State details of amendments proposed

Our Reference WL-3/MP
Your Reference H14/0948&1083/95
Date 01.12.95.

**EXTENSION TO FASTFRUIT DISTRIBUTION WAREHOUSE
PUDDING LANCE, SPALDING, Lincs**

1. The proposal for the loading bays is now to be reduced from seven loading docks to six. We enclose 4no copies of revised drawings F01A, P02A and Sketch SK1A indicating the same.

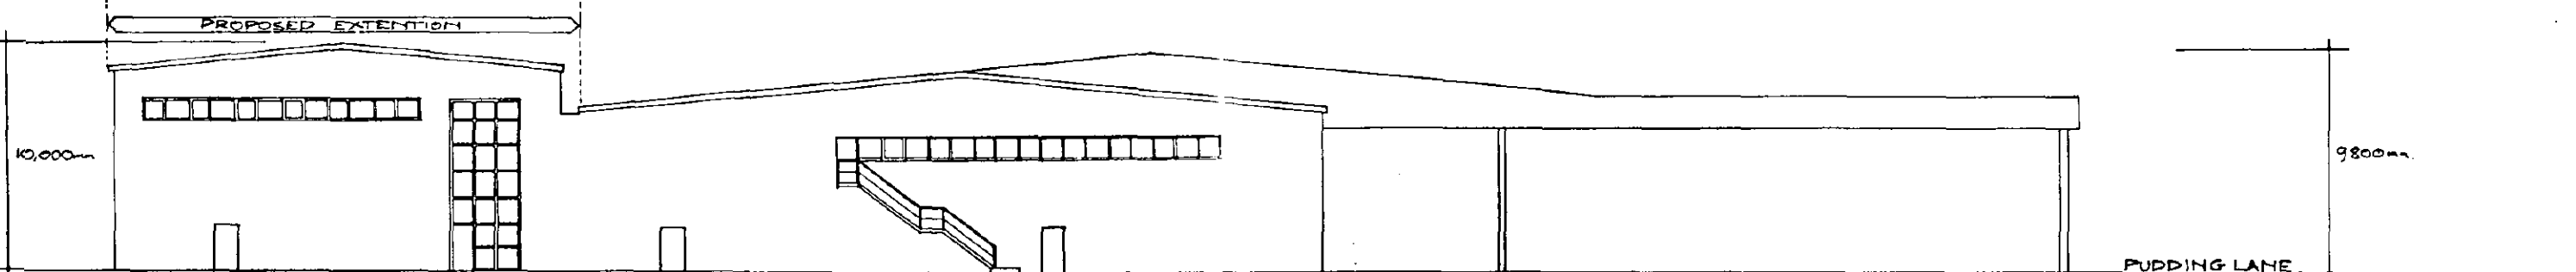
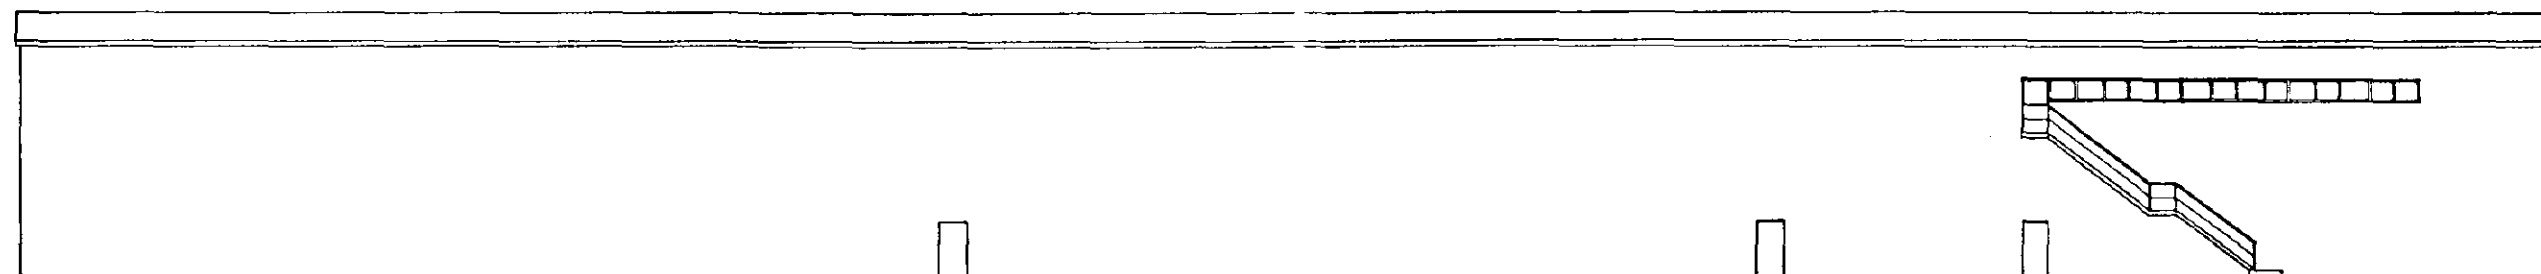
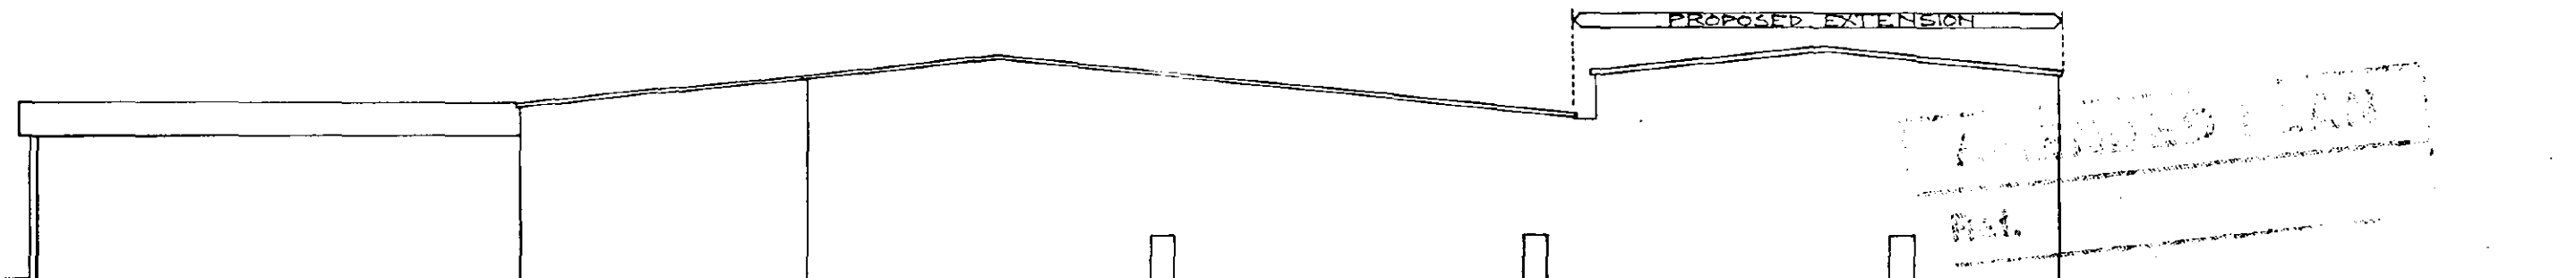
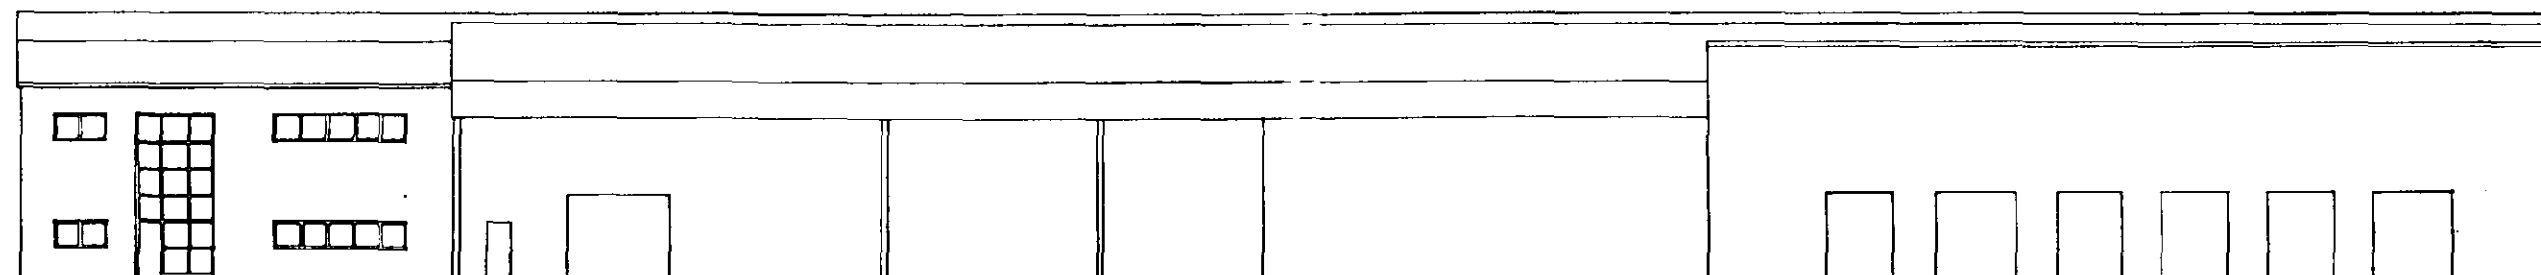
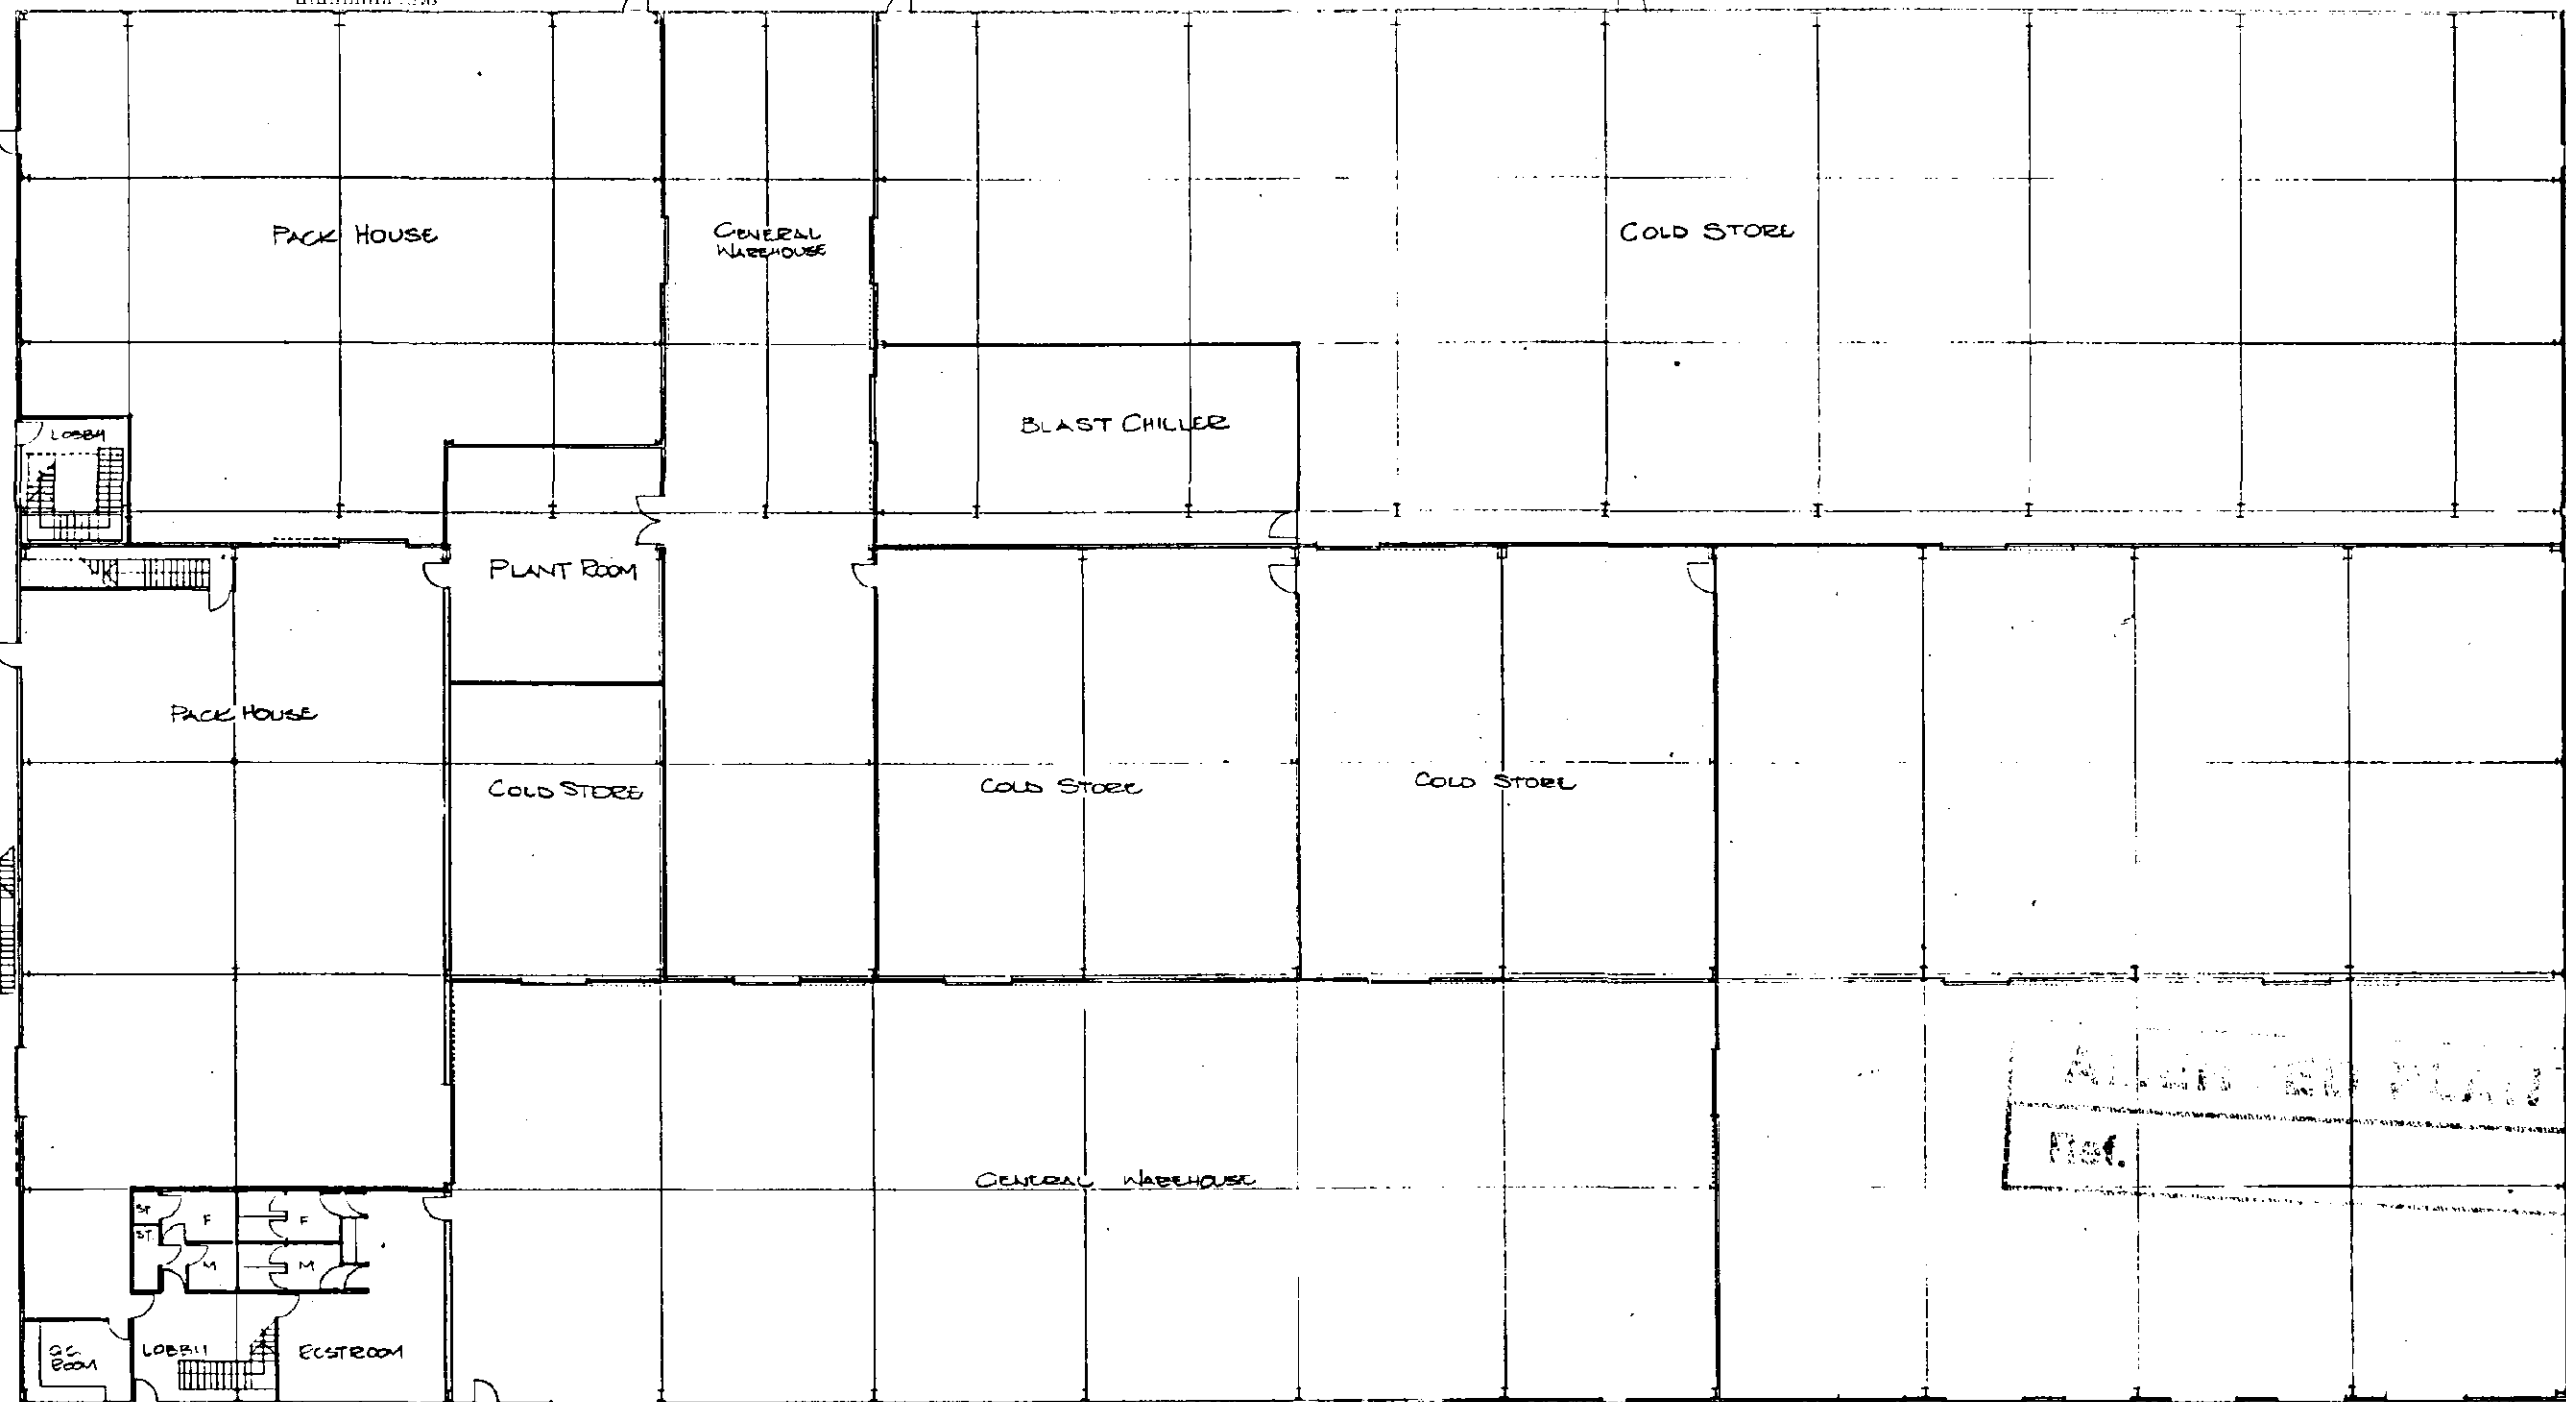
Reduction to 6 loading docks
